**PLANNING WORKSHEET 11 – DELEGATED / PCG REPORT - GENERAL**

<b>Application Ref.</b>	22/00863/FUL	
<b>Site Address</b>	Land Including Littlewood House Wheatley Road Sturton Le Steeple Retford Nottinghamshire	
<b>Proposal</b>	Demolition of an Existing Bungalow and erection of a Detached House and Garages with new vehicular access	
<b>Case Officer</b>	Eleanor Grant	
<b>Decision Level</b>	Delegated	
<b>Recommendation</b>	Refuse	
<b>Reason(s) for PCG referral</b>		
<b>PCG Sign off and date</b>		
	<b>Signature</b>	<b>Date</b>
<b>Case Officer</b>	Ellie Grant	09/08/2022
<b>Authorised signing Manager</b>		10 <sup>th</sup> August 2022

client			
project	Mr and Mrs B, Foster Little Wood House Sturton le Steeple DN22 9HU	drawing	Revised Floor Plans
drawn by	JB	scale	1 / 50 @ A1
date drawn	12.05.2022	status	PRELIMINARY
		drawing no.	P22.0510.06
		rev	C

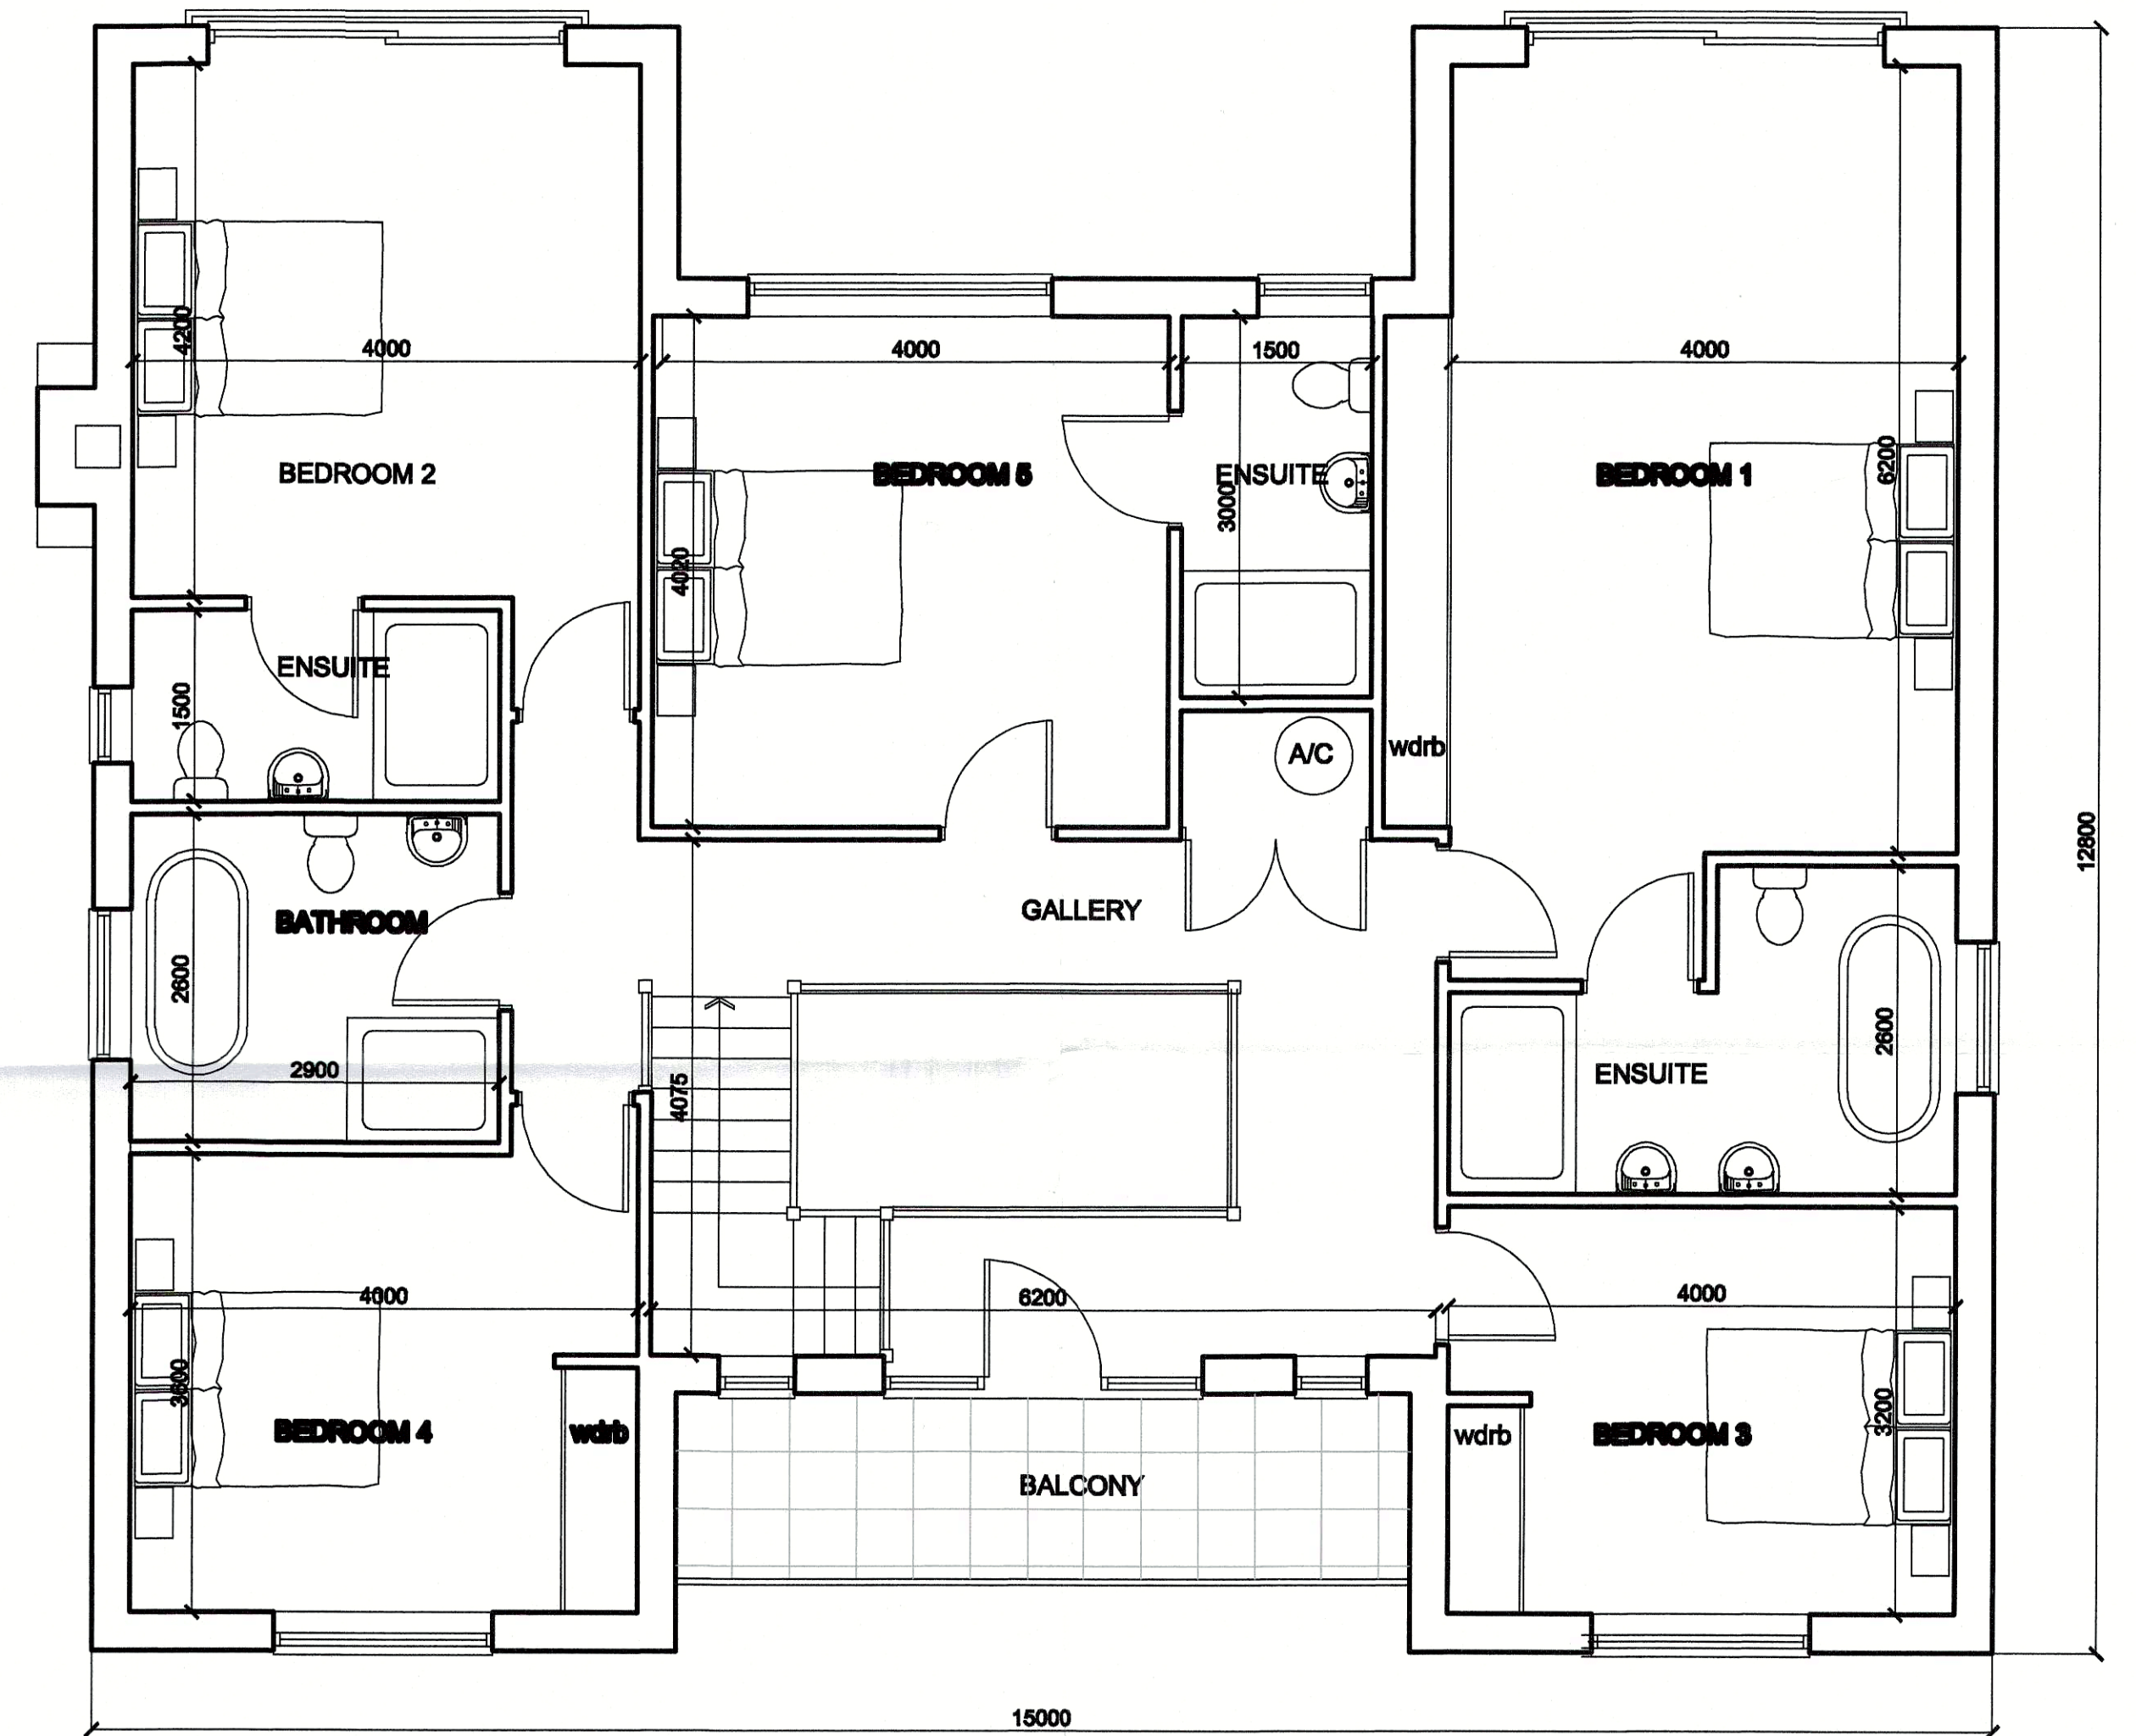
However, there are concerns in regards to design. Whilst the footprint provided is not significantly dissimilar to that of the original dwelling, the design is considered insensitive to the surrounding context. The property sits in a rural location in the open countryside, outside of any development boundary. There are 7 properties here, including Littlewood House, which are considered to be of a low density of development. The properties vary between two storey dwellings and bungalows, with both of the immediately adjacent properties to Littlewood House being bungalows. The proposed dwelling will be approximately 8.9 metres to ridge height. When compared, this will be around 2 metres taller than existing two storey properties in this location. As such, the scale is of concern to the Officer as the property will stand noticeably taller than the surrounding properties as a stark contrast, meaning that it will not assimilate with the form of development in this location and will have a domineering impact to the adjacent properties.

The proposed dwelling is not considered to pose risk of overshadowing to Cranleigh as the 45 degree right to light would be preserved. There would also be no loss of privacy; there will be one first floor window which will serve a bathroom which would be conditioned to be obscurely glazed.
